Your Ref: OWPC15909
Our Ref: LU/282/17/RES 01-09-2017
Please ask for:
Michael Eastham

Approval of reserved matters following outline consent LU/355/10 for access, appearance, layout & scale relating to development comprising of up to 162m2 of floorspace for A1/A2/A3 local facilities, with 5 No. residential apartments at first & second floor comprising of 3x2 bed & 2x1 bed with associated parking, bin stores, cycle parking & store. Associated changing facilities which comprise of a single storey building sited towards the open space & playing fields area to the North -East of phase 2

Land North of and South of Railway Courtwick Lane Littlehampton

Drawing No: 16.041.004

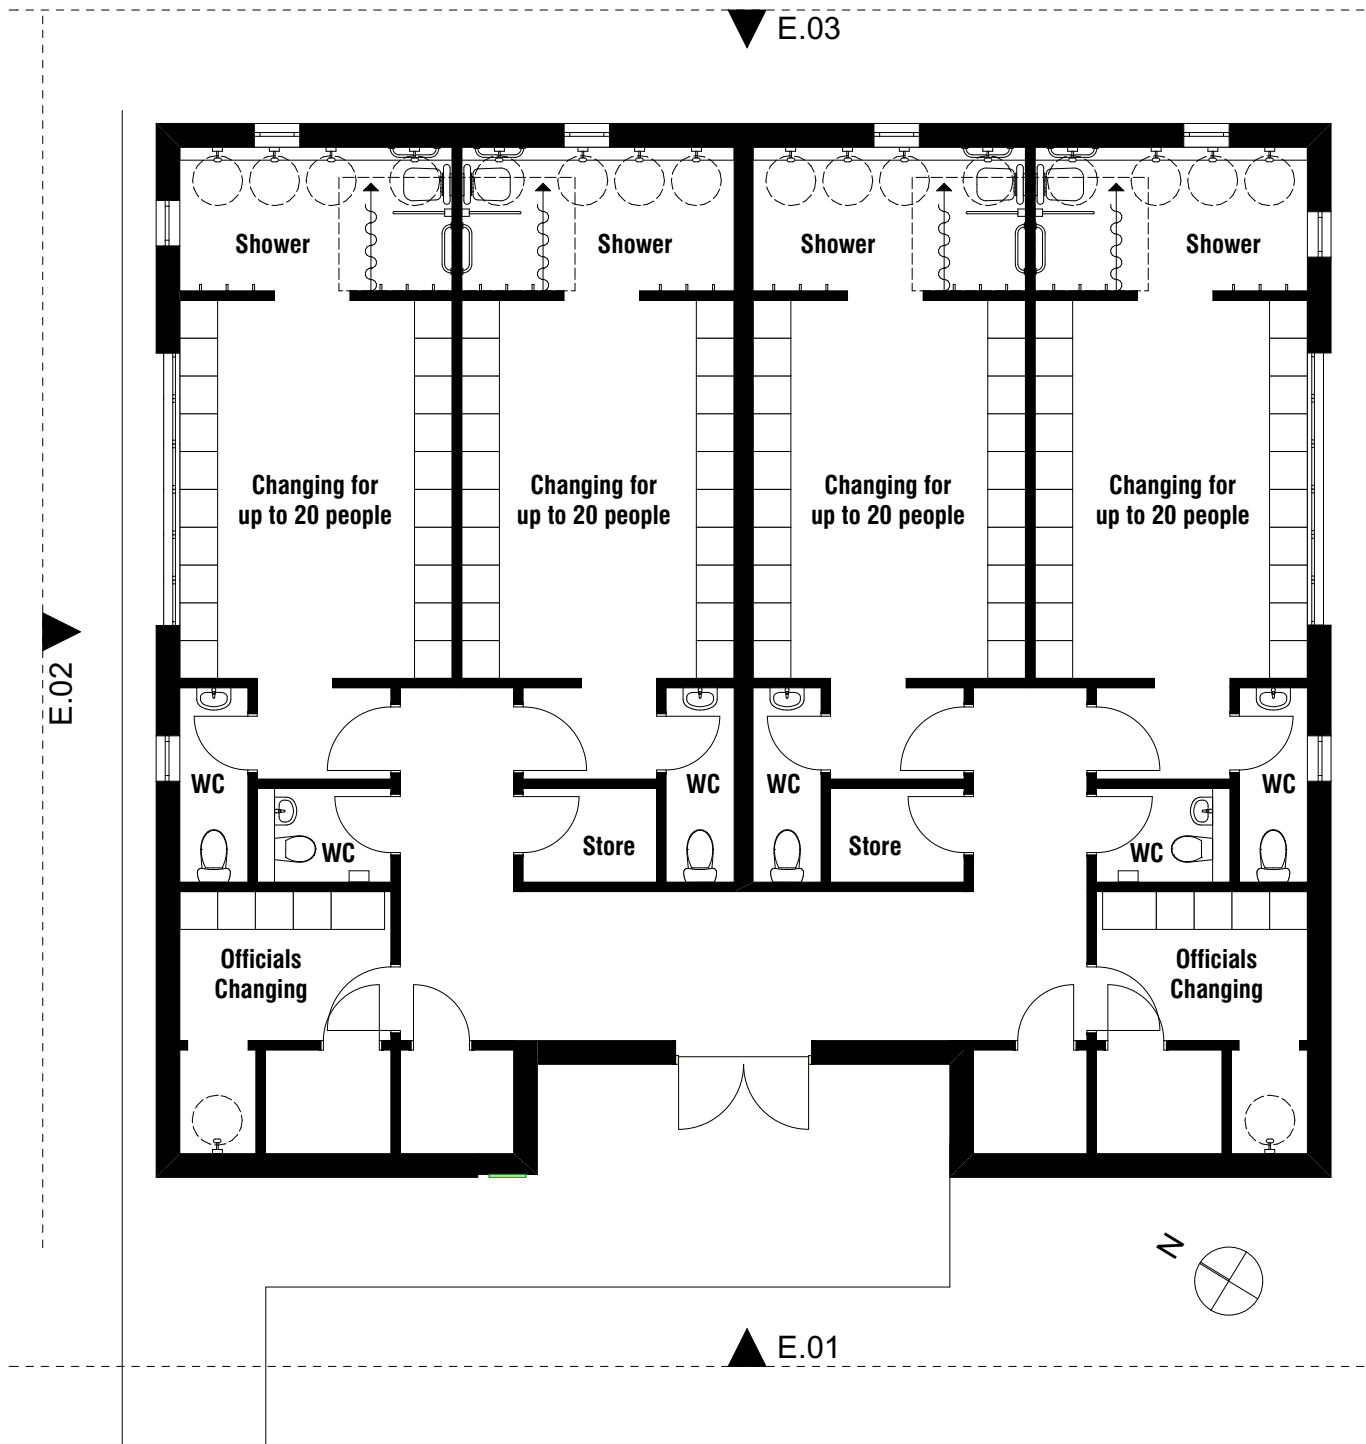
Changing Facilities plan dwg. 16.041.004 shows a potential changing for up to 80 people plus changing for officials, possibly 100 people using the facility at a time plus spectators. Parking being provided, according to the application covering letter is for approximately 20 cars on "grasscrete", where would the other possibly 80 cars park?

Drawing No: 16.041.005

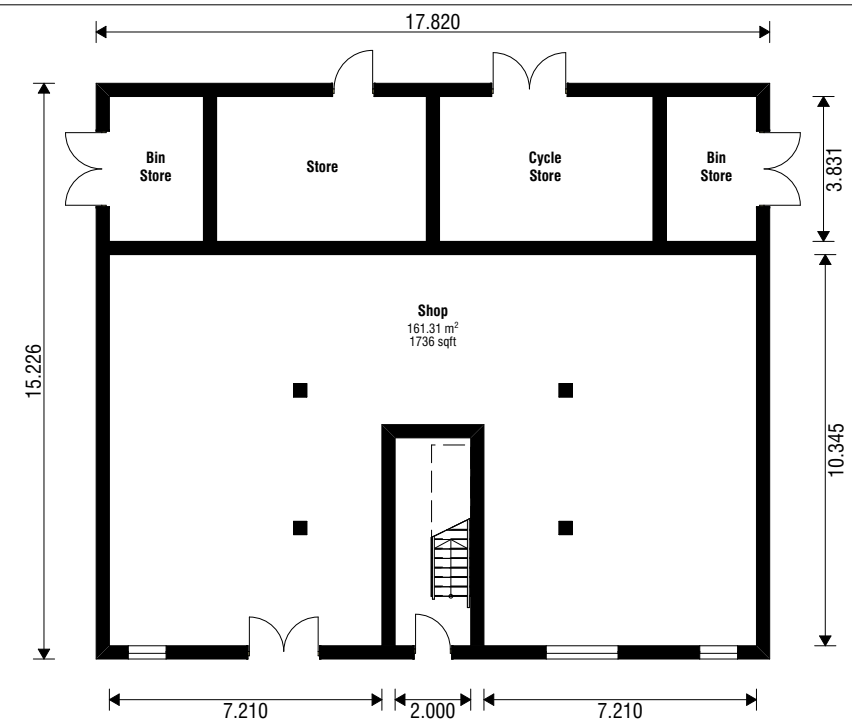
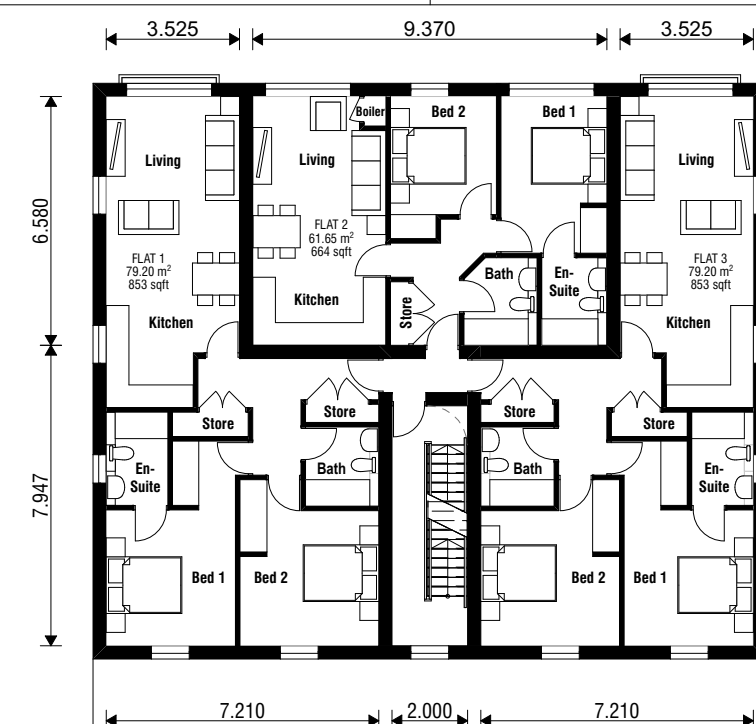
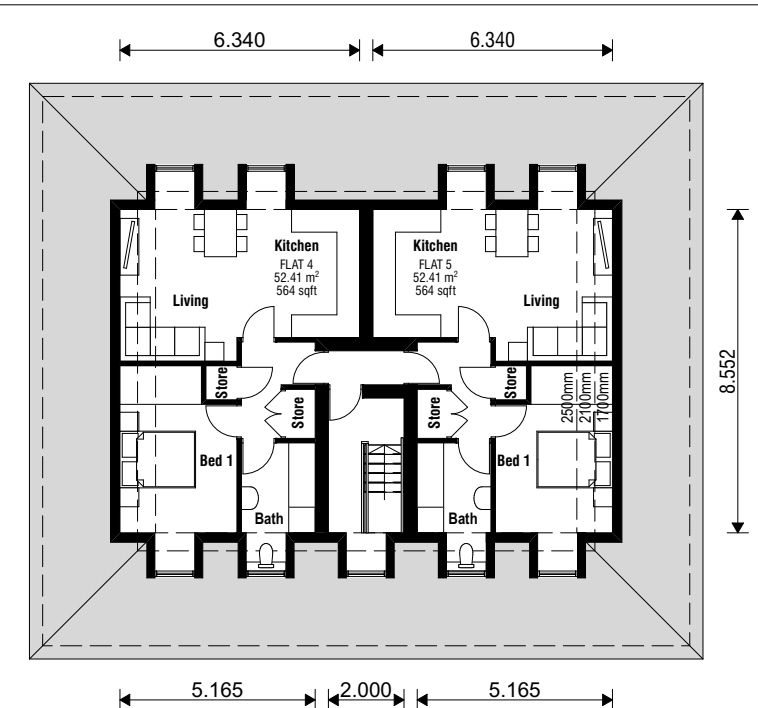
No staff facilities or toilets shown for the shop 16.04.005 Rev D

Drawing No: 16.041.001

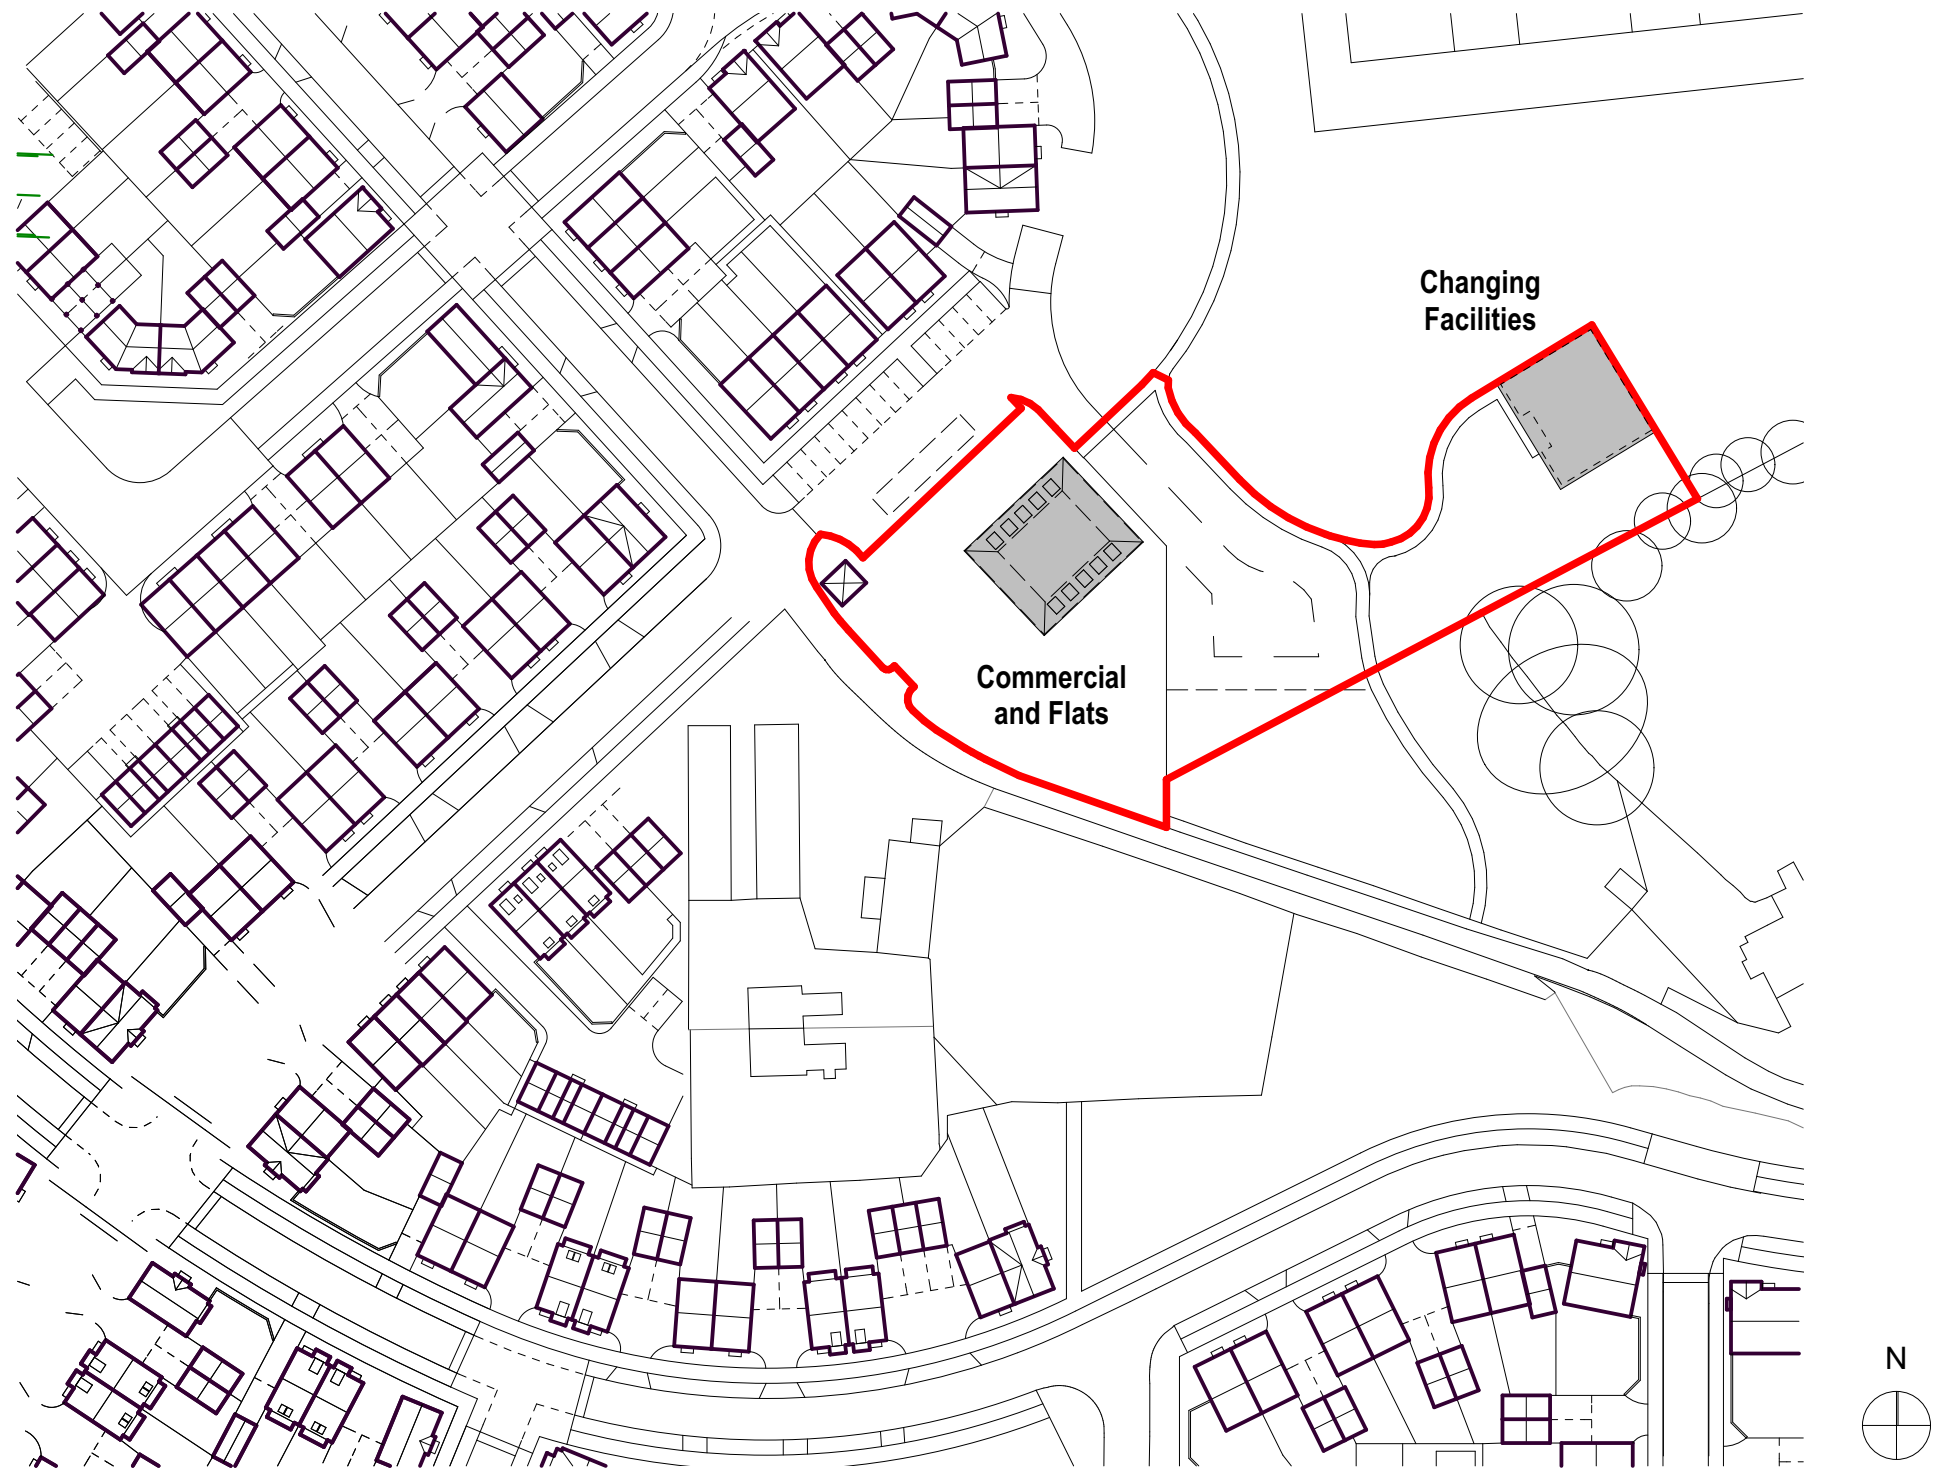
Site plan dwg. 16.041.002 Rev B and Location plan dwg. 16.041.001 Rev A show an incorrect and out of date site plan surrounding the application site. Plans incorrectly show 8 properties and 14 parking spaces within the vicinity of the proposed shops/flats. The Barratt site plan taken from their website shows 10 properties and 16 parking spaces opposite the shops/flats plus a further 8 properties that were approved on planning application LU/24/17/PL, adjacent to the site for the current planning application and missing from the site and location plan.
